REQUEST

Current Zoning: CG (general commercial) and N1-A (neighborhood 1)
Proposed Zoning: R-8MF(CD) (multi-family residential, conditional)

Approximately 13.02 acres located on the south side of Albemarle Road, east of Manchester Lane, and west of Wilgrove-Mint Hill Road.

The petition proposes to develop the parcel in east Charlotte, with up to 60 single family attached dwelling units accessed off private alleyways connecting to a new public street through the site.

RZ-1.0

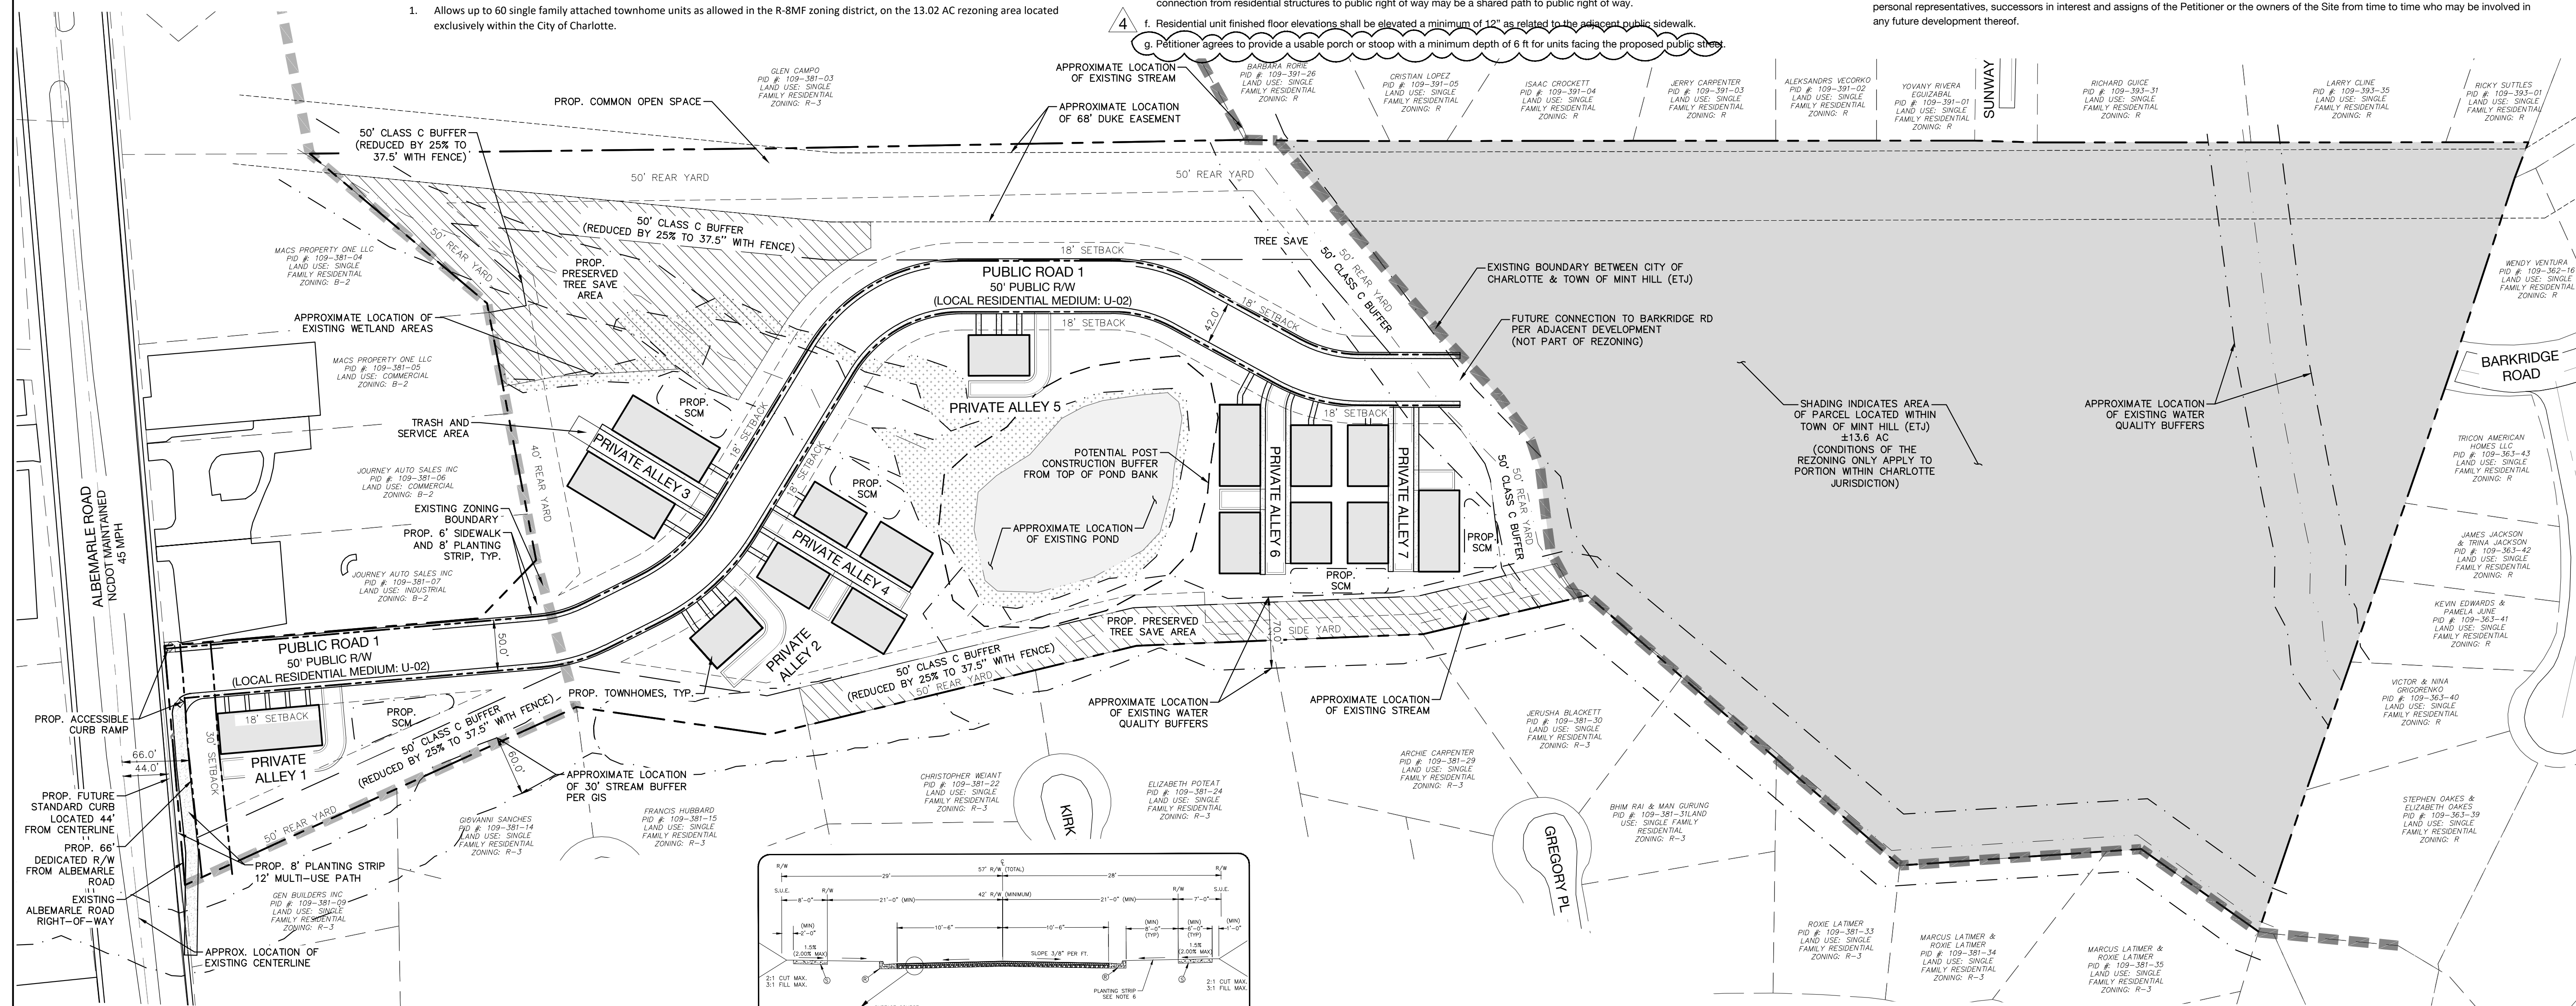
1. Adjust setbacks to be measured from the full R/W of a U-03A street type per CDOT memo.
2. Show the Ordinance required buffer along the rear of parcels ending in 38107, 38106, 38105.
3. Staff requests a note be added limiting the maximum number of units per building to 4.
4. Provide an architectural note committing to the provision of a usable porch or stoop at least 6 ft feet for units facing the proposed public street.
5. Provide an architectural note describing the pedestrian entrance at the end of buildings (on the either side of Alley 3 for example). Confirm if that is the entrance to the building or to the individual end unit.
6. Amend Permitted Uses Note 1, to say "Allows up to 60 single family attached townhome units as allowed in the R-8MF zoning district on the 13.02 ac rezoning area located exclusively within the City of Charlotte."

7. Show, label and dimension the stream buffer that per GIS is a 30 ft stream buffer located along the northwest property line.

8. Add conditional note to dedicate 66' right-of-way from the road centerline.
9. In coordination with NCDOT, label and add a conditional note to constructing a right turn lane on Albemarle Road.
10. Revise site plan and add a conditional note to commit to constructing Public Road 1 to a Local Residential Wide Street Section (CLDSM U-03A).
11. Revise conditional note with SUE to have 2' instead of 1' as shown in conditional note 7. 2' is necessary for the maintenance of the path.
12. Clearly show and label accessible curb ramps at the corner of Public Road 1 and Albemarle Road.

13. Remove proposed density from the development data table. Change Max Density to "Max Allowed Density" and adjust the numbers to match number of units (60) proposed and the density of 4.6 accordingly. The max and proposed units/density are the same with the conditional zoning.
14. Update the existing zoning in the Dev Data table to reflect CG and N1-A per UDO translation.
15. Change R-12MF to R-8MF in Note 2 General Provisions and in Note 1 of Architectural and Design Standards.
16. Amend the setback along Albemarle Rd in the Dev Data table to reflect 30 ft from future R/W.
17. Change the word "hatch" to Shaded in the label indicating area within Mint Hill.
18. Amend the misspelling of "location" in the label indicating approximate location of water quality buffers along the southern edge of the site.
